From: [REDACTED]
Sent: 27 June 2019 08:53
To: Amber Willard
Subject: Re: aw/117/19/hh

I am writing in relation to AW/117/19/HH at 113 Rose Green Road.

1st floor plan

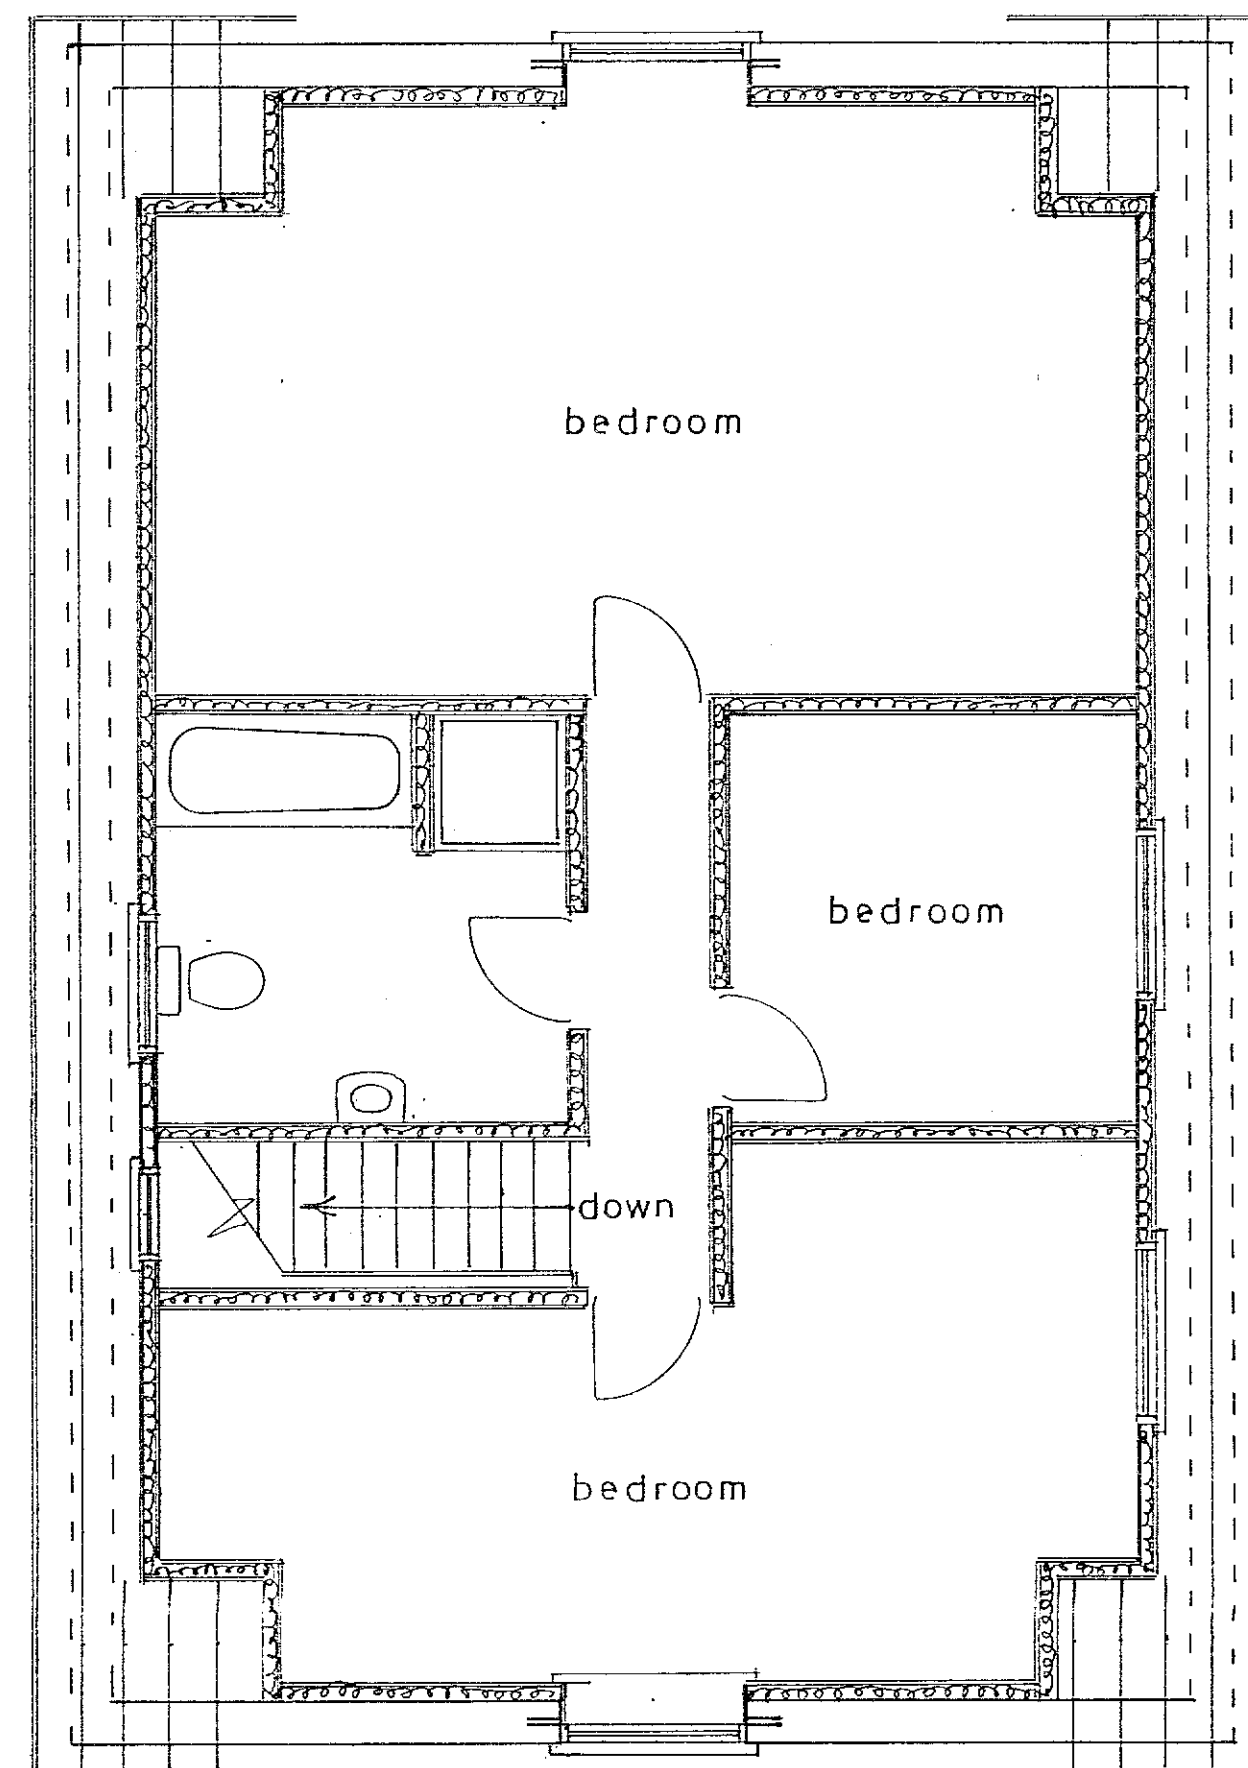
My manager and I have concerns about the front bedroom window to the western dormer. As the dwelling sits forward of the neighbouring property, we believe there is potential for views into the front windows of the yellow house to the west.

I understand it is not ideal to have an obscured bedroom window and therefore I write to see if you propose having a fan light window with it obscured to height of 1.7m or alternatively if it can be re-sited at all.

I have no problem with including obscured glazing to the front bedroom west facing window as I can provide a necessary Building Regulations 'Means of Escape' casement opening to the front window frame.

Would you prefer that I mark it on the plans or will you just place a Condition on the approval document.
